**SOILS AND GEOLOGY STUDY  
THE COMMONS AT FALCON FIELD  
PARCEL NOS. 43070-00-001 AND 430720-00-015  
WOODMEN ROAD AND HIGHWAY 24  
EL PASO COUNTY, COLORADO**

January 20, 2021  
Revised July 21, 2023

PCD No: SP-232

NORTH POND PLAN VIEW  
SCALE: 1"=40'

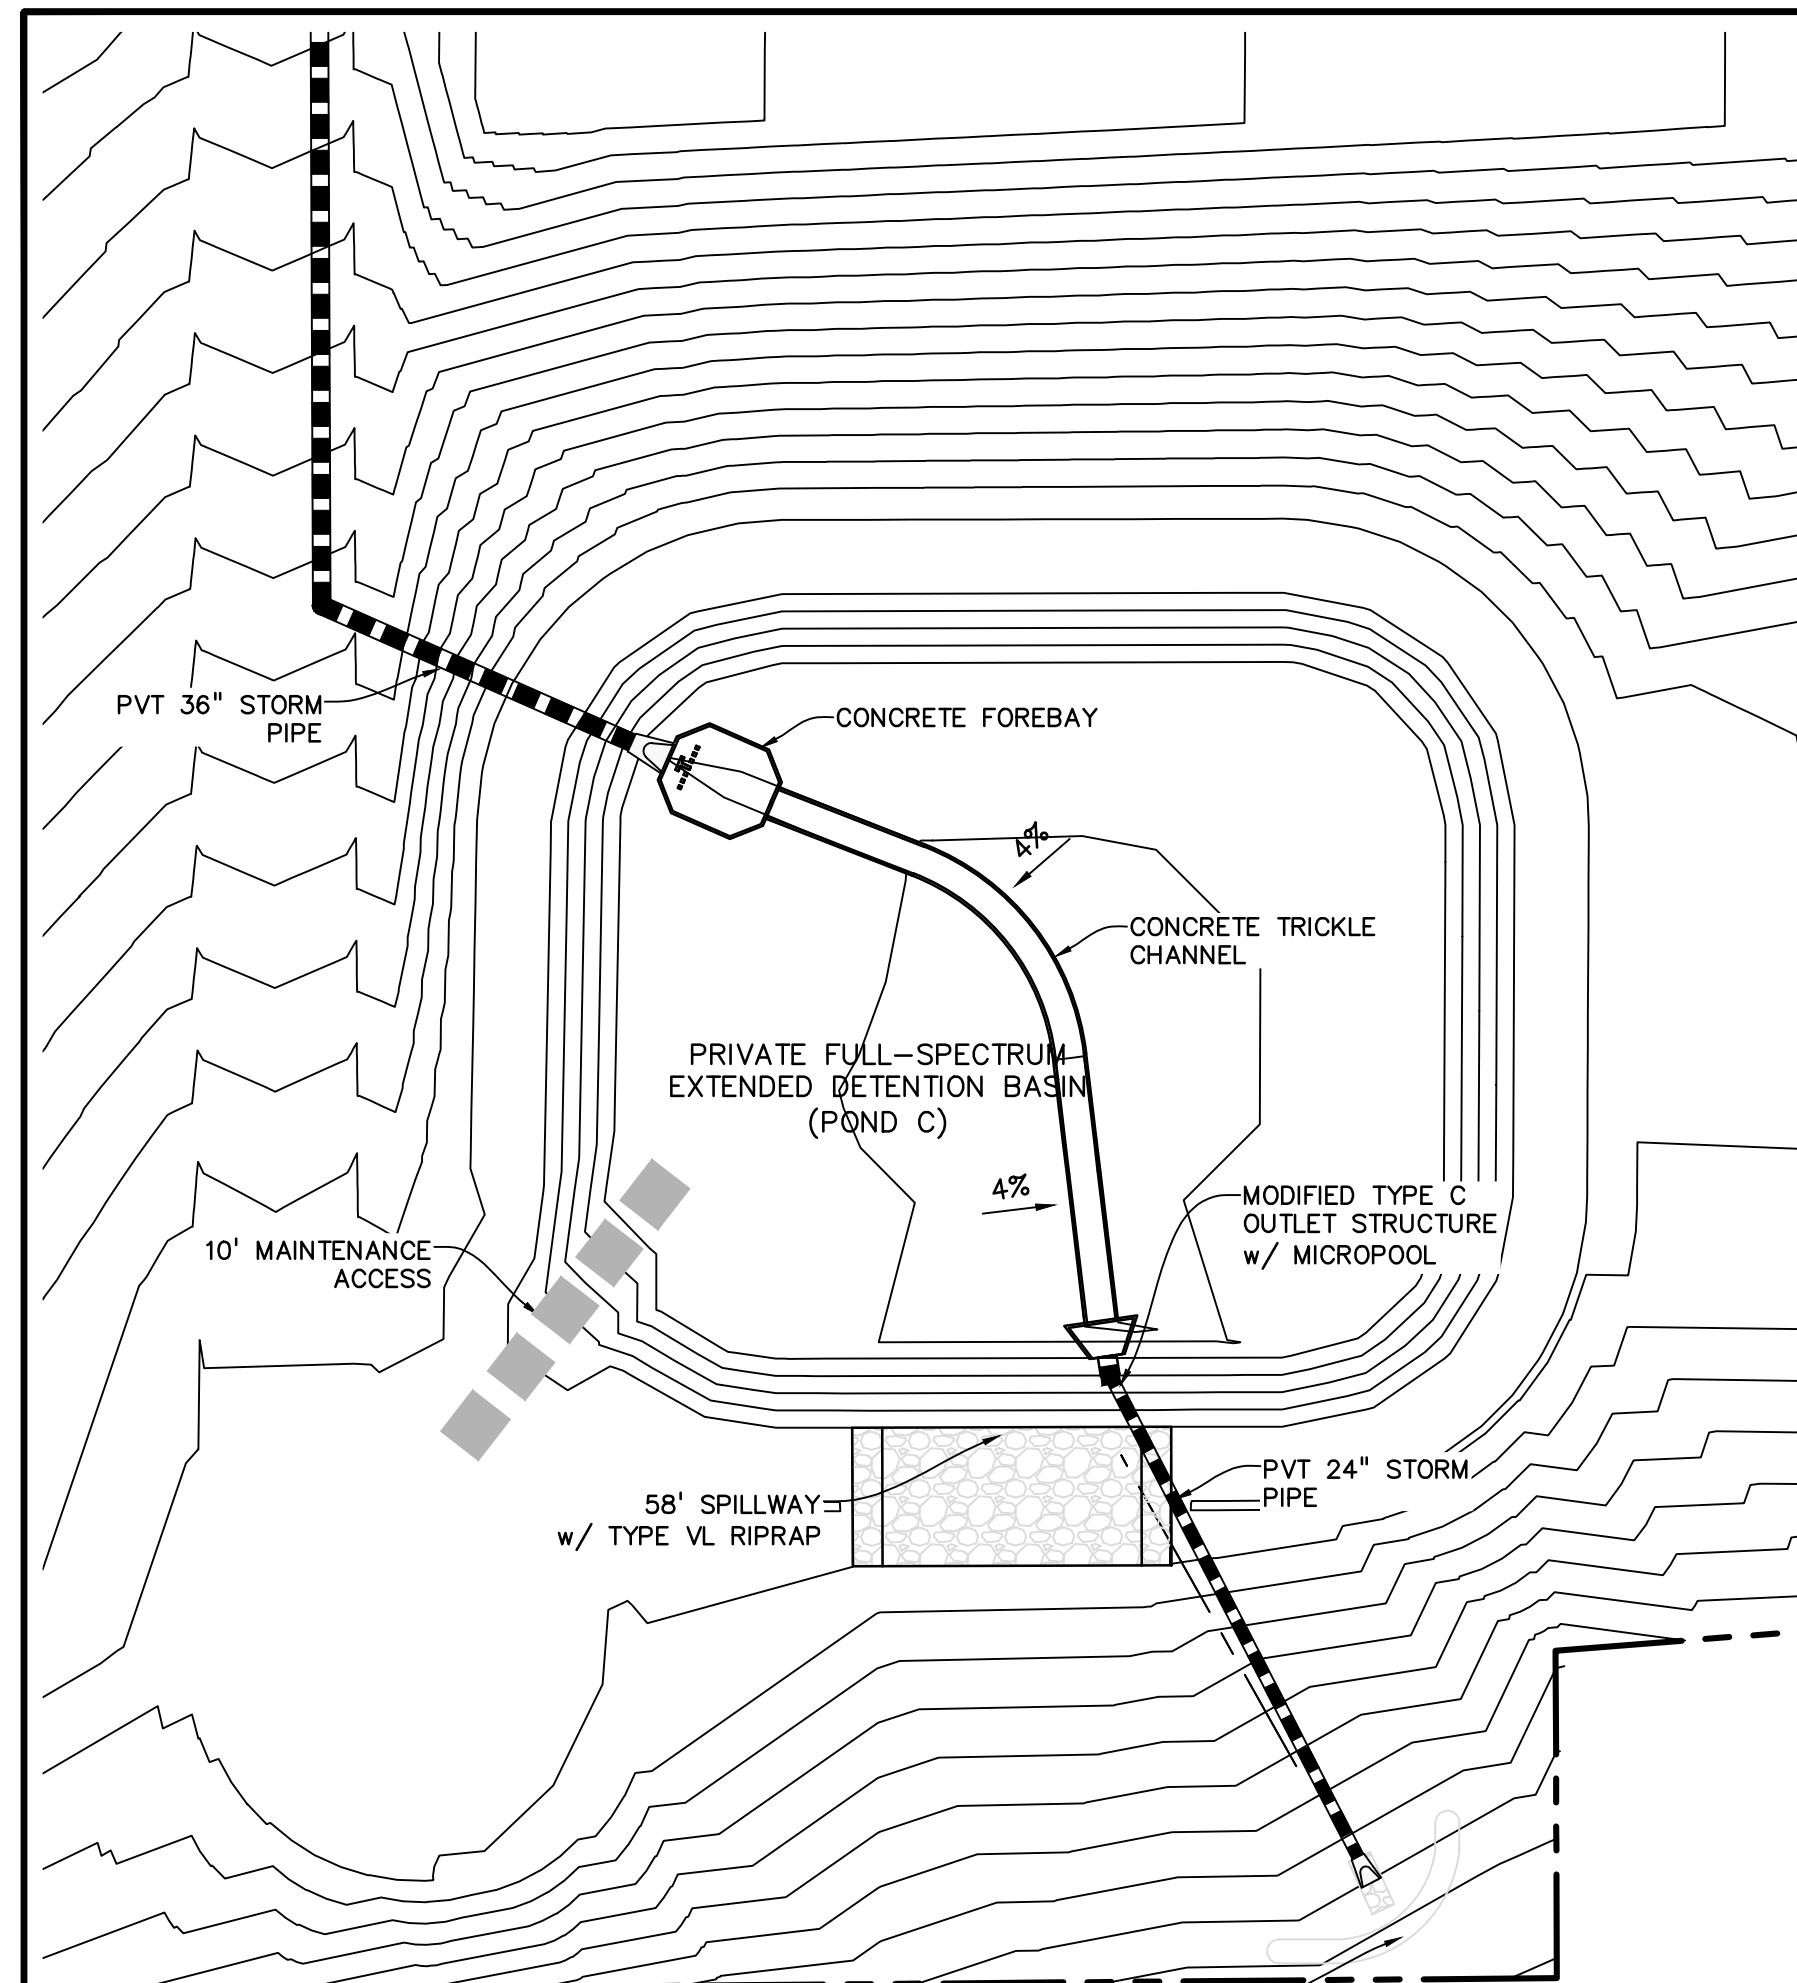
Discuss proposed mitigation for the ponds as well. In Section 6.1 it is stated the ponds will be located in areas where groundwater will flow.

Discuss recommended mitigation for the ponds (like a clay or geomembrane liner or other methodology).
